From: Karl Roberts
Sent: 06 September 2019 09:51
To: Joney Ramirez [REDACTED]
Subject: Application A/100/19/PL - Arundel Acre, Angmering

I have noted the case being made for the provision of a site for travelling show persons and this flows in favour of the proposal. However, any use, even if it is supported by policies in the Local Plan must have a safe means of access. I have set out for your information the response received from WSCC regarding the visibility issues. Unless the visibility can be satisfactorily addressed in both directions then it is likely that my recommendation would be one of refusal. Please advise within the next 7 days whether you wish to make any additional representations or submit additional material (and if so how long would you need to do this) otherwise I will proceed to make my recommendation.

Access Junction with Visibility Splays

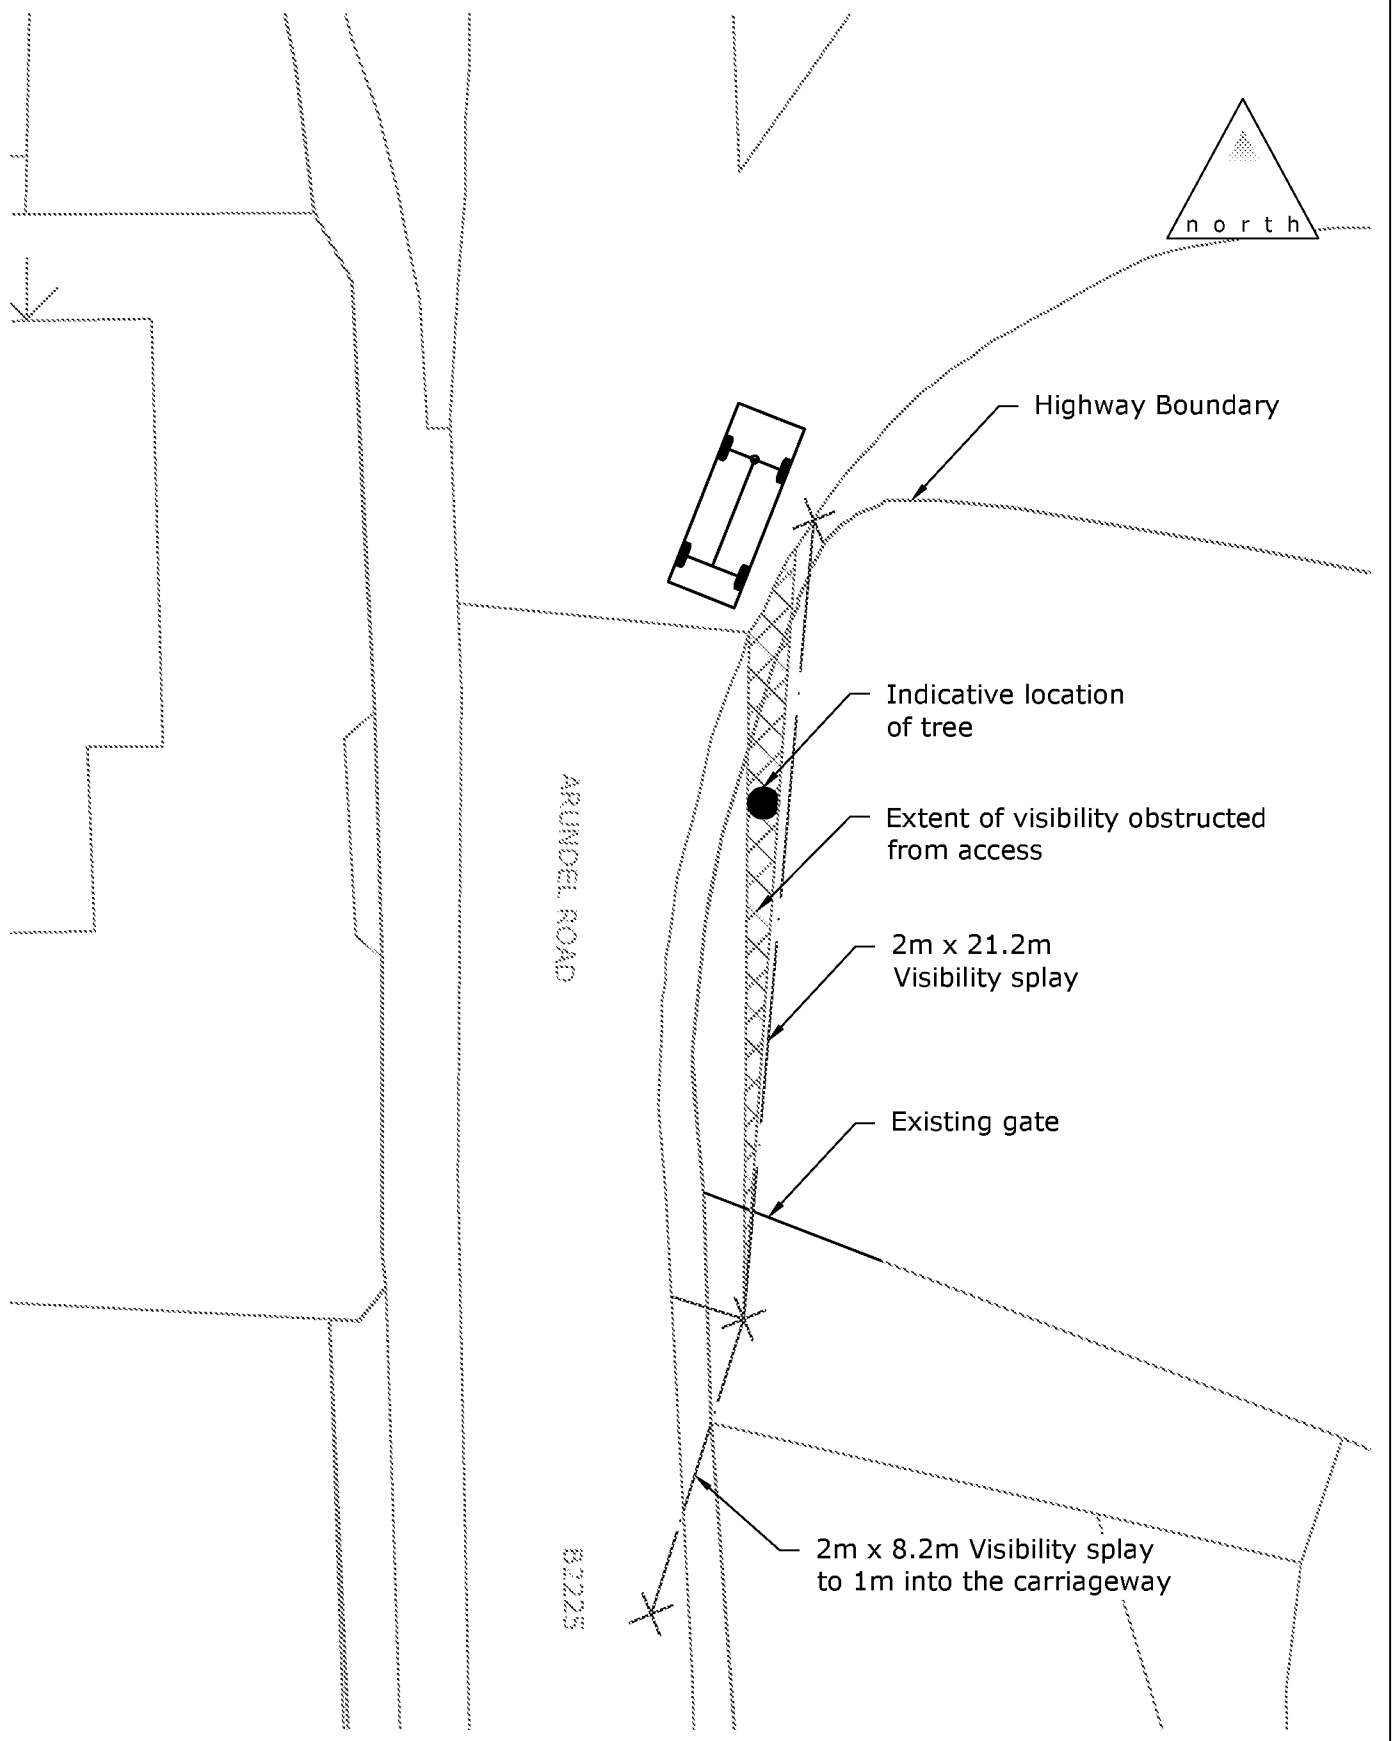
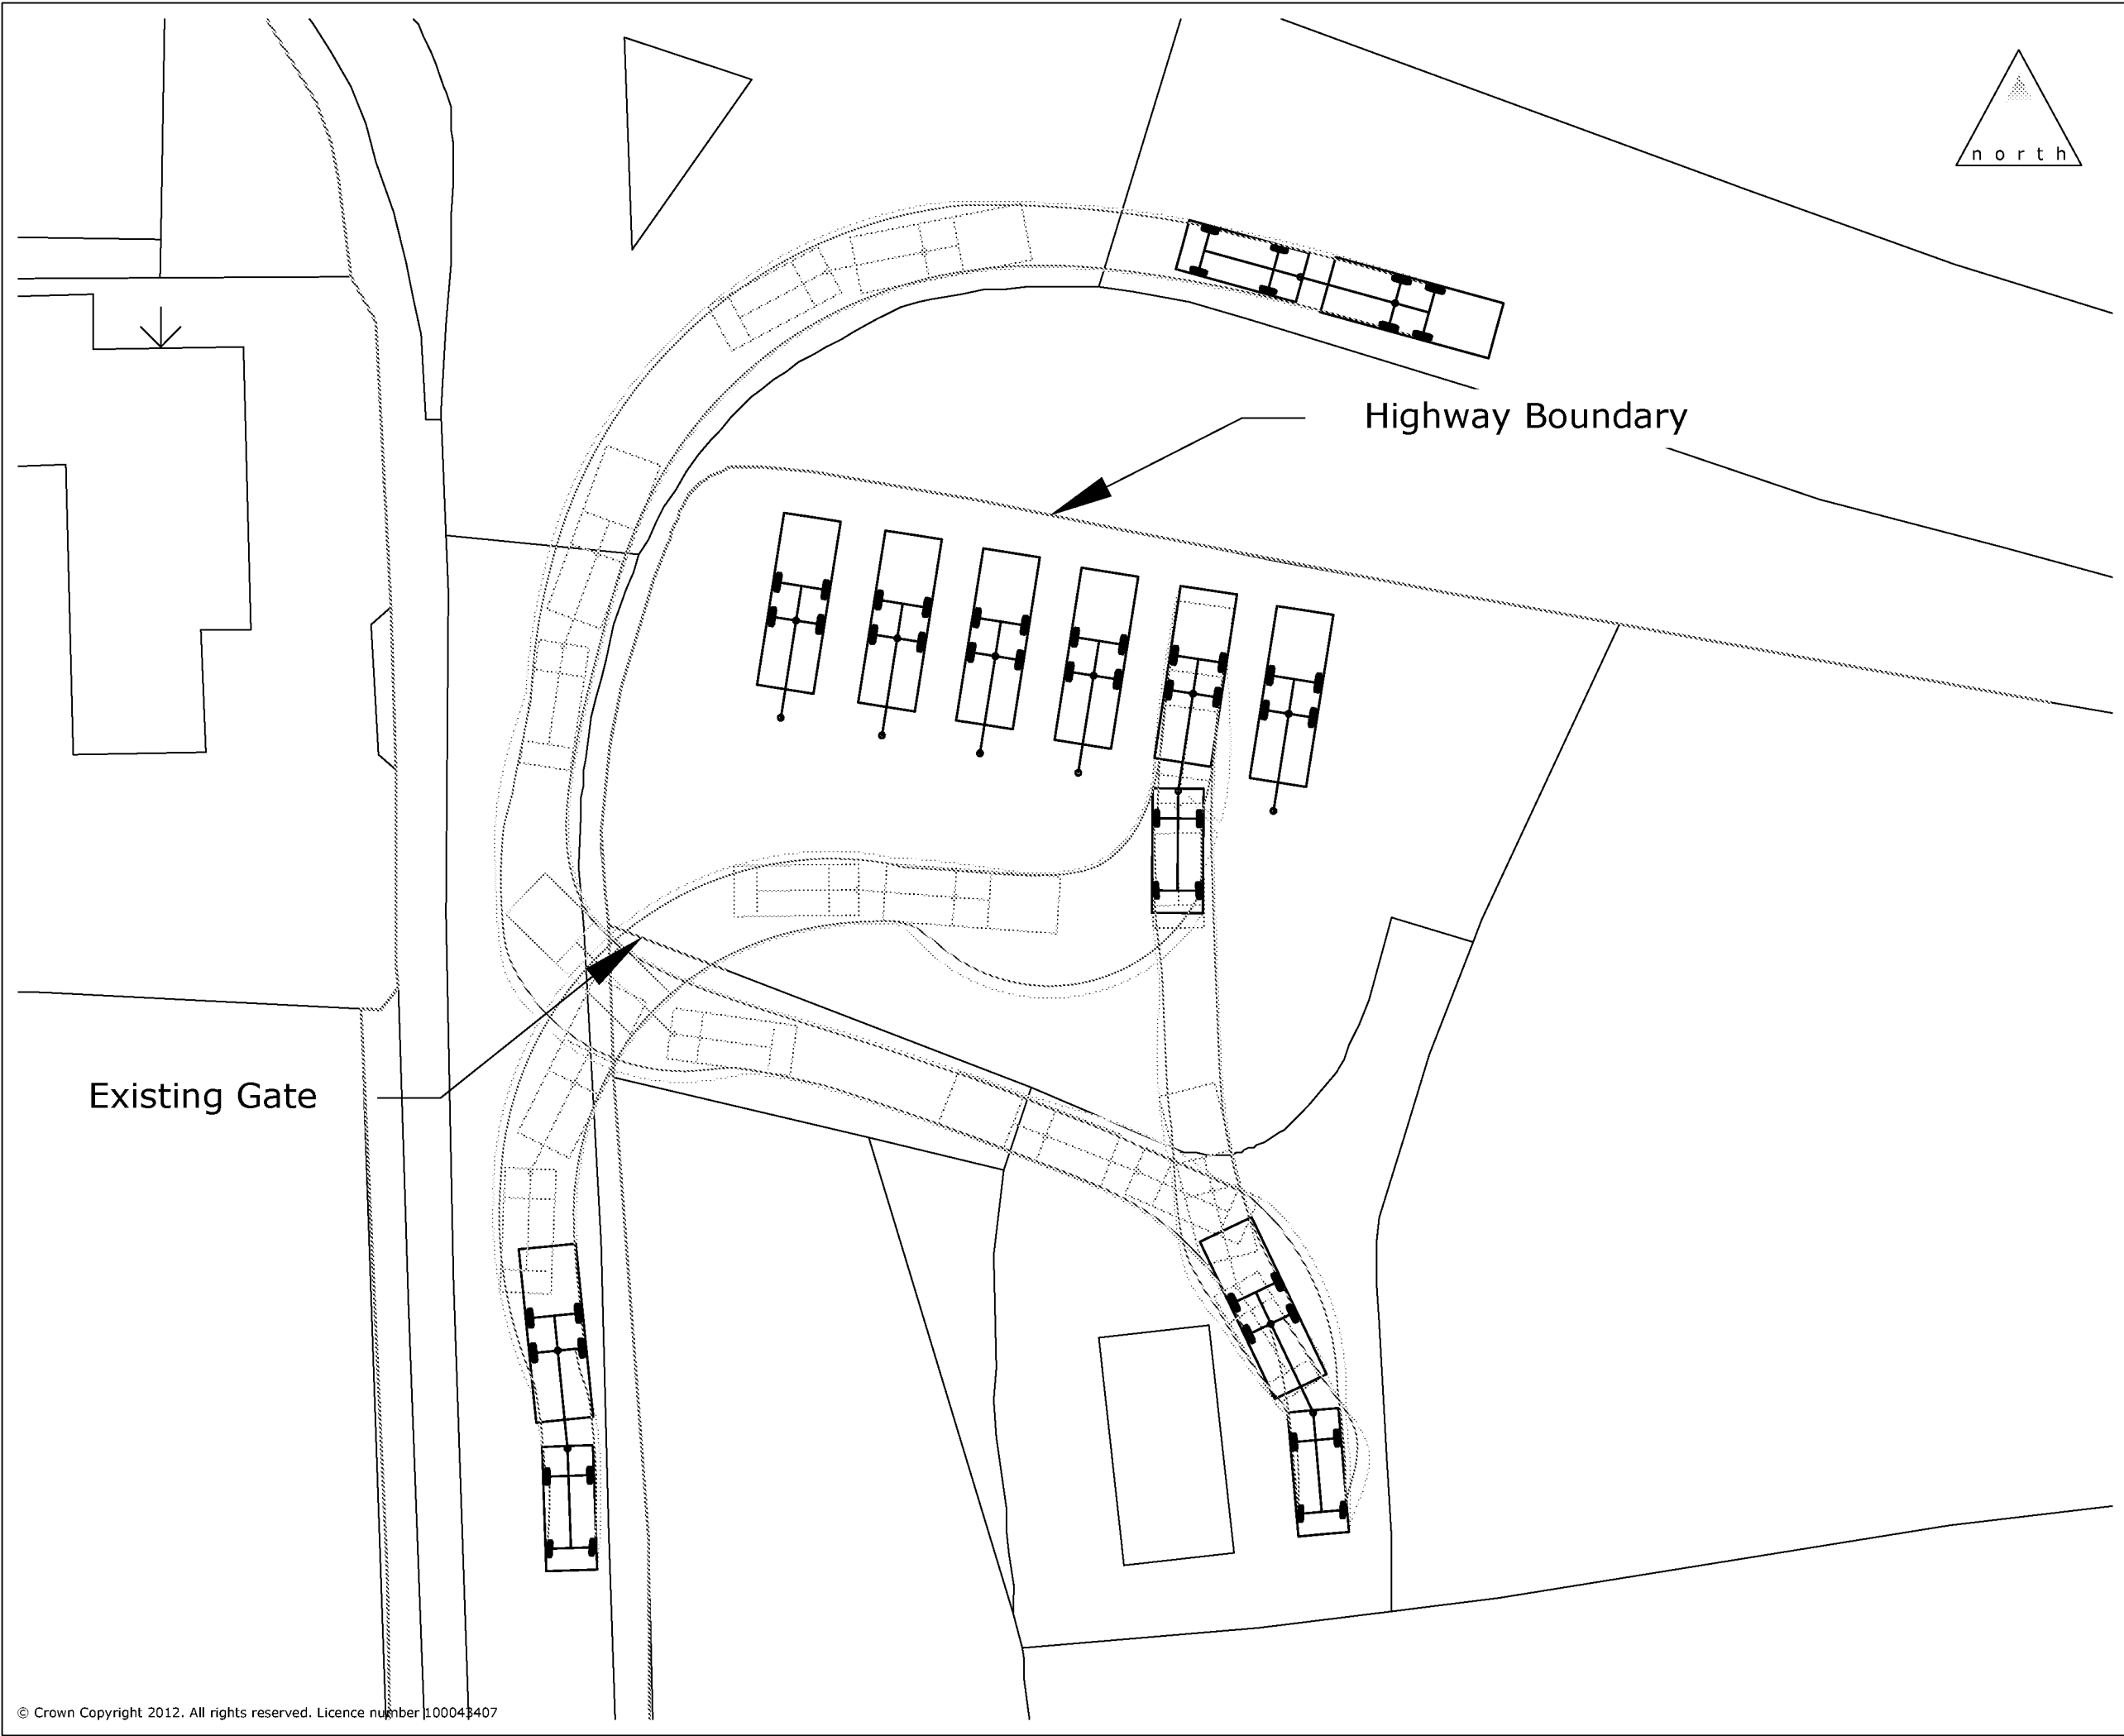
As per A/3/18/PL it was accepted that a visibility splay of 2.4 x 21 metres is achievable and would be considered an improvement against the existing situation, where visibility is extremely limited.

As previously assessed under A/111/17/PL & A/3/18/PL visibility in the trailing direction was extremely limited due to 3rd party land. The maximum available visibility was demonstrated as 2.0 x 8.2 metres, measured 1.0 metre into the carriageway. The LHA did not accept that a 2.0 metre 'X' distance should be used. Nevertheless this would only equate to the stopping sight distance of an approach speed of 7 mph as per Manual for Streets calculation coefficients.

No evidence, previously or as part of this application has been provided to demonstrate such visibility is suitable or that any significant improvements could be made.
